# CITY OF ALBUQUERQUE

RE: **Wienerschnitzel**  
**2551 Corona Dr. NW**  
**Request Permanent C.O. - Accepted**  
**Engineer's Stamp Date 5-10-16 (File: H11D069)**  
**Certification date: 11-10-16**

**RE: Weinerschnitzel  
Grading and Drainage Plan  
Engineer's Stamp Date 5-10-2016 (File: H11D069)**

**From:** Abiel X. Carrillo  
**Sent:** Friday, May 13, 2016 1:16 PM  
**To:** 'joe.cross@sesincusa.com'  
**Subject:** H11D069 - Wienerschnitzel Westbluff  
**Attachments:** SO 19 NOTES with sig C.DOC

SHEET NUMBER
C-2

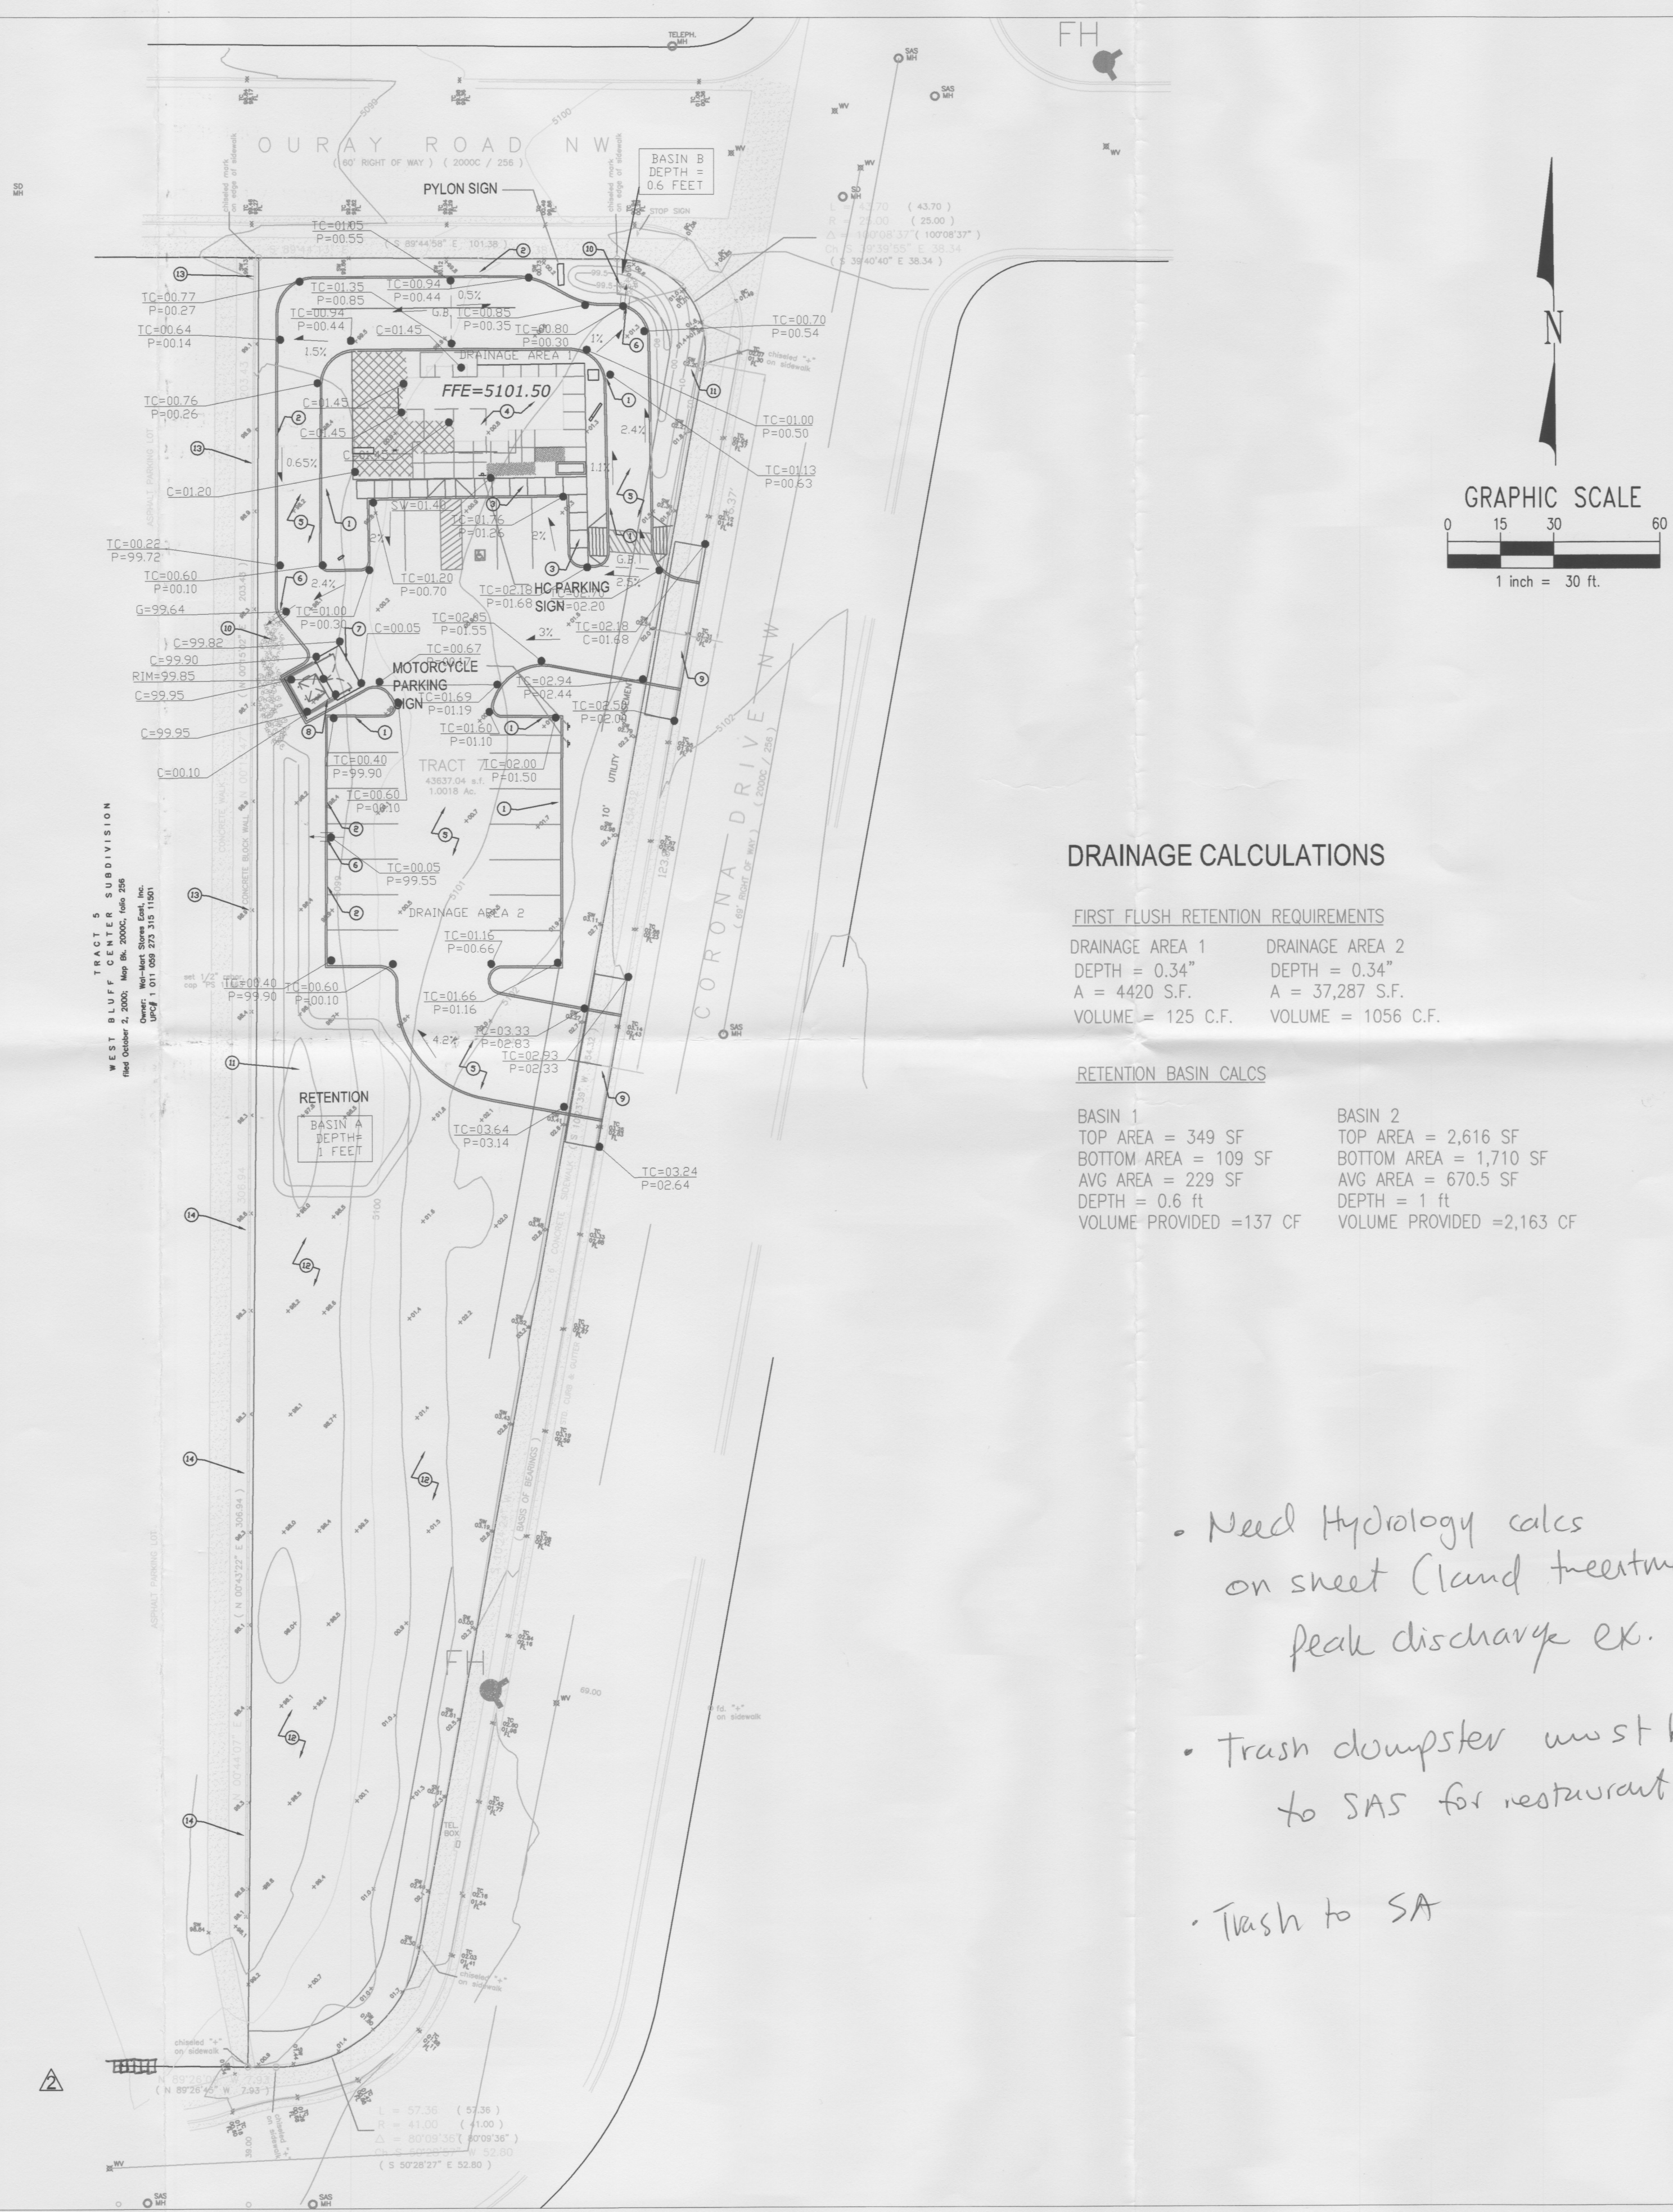
1. Many of the construction notes generally call for the Contractor to build elements per local standards. If curb and gutter and other features are to be constructed per a City Standard Drawing, they should be called out specifically. For example, the City's most standard curb is 8" tall, which might not be the intent around the building. Otherwise, include details for the builder to follow.

2. The plan needs to include hydrology calculations and references to any applicable commercial masterplans. It appears that this site might be included in the plan for the adjacent site (Hydrology File H11D059). The calculations and a narrative must describe how this project is in compliance.

- a. Drainage Basins need to be shown on the plan.
3. The northernmost first flush pond will need an emergency overflow onto the right of way. This can be accomplished with a sidewalk culvert (reference the City's standard drawing). Private drainage facilities in the Right of Way are permitted through a "Special Order 19". I have attached the SO-19 Standard Notes that need to be included on the plan.

4. Include two hardcopies of the plan (required for projects with SO-19 Permit request).
5. Trash enclosures need to drain directly to the Sanitary Sewer line. Utility submittals are not required, but a note on the plan must reference the connection.
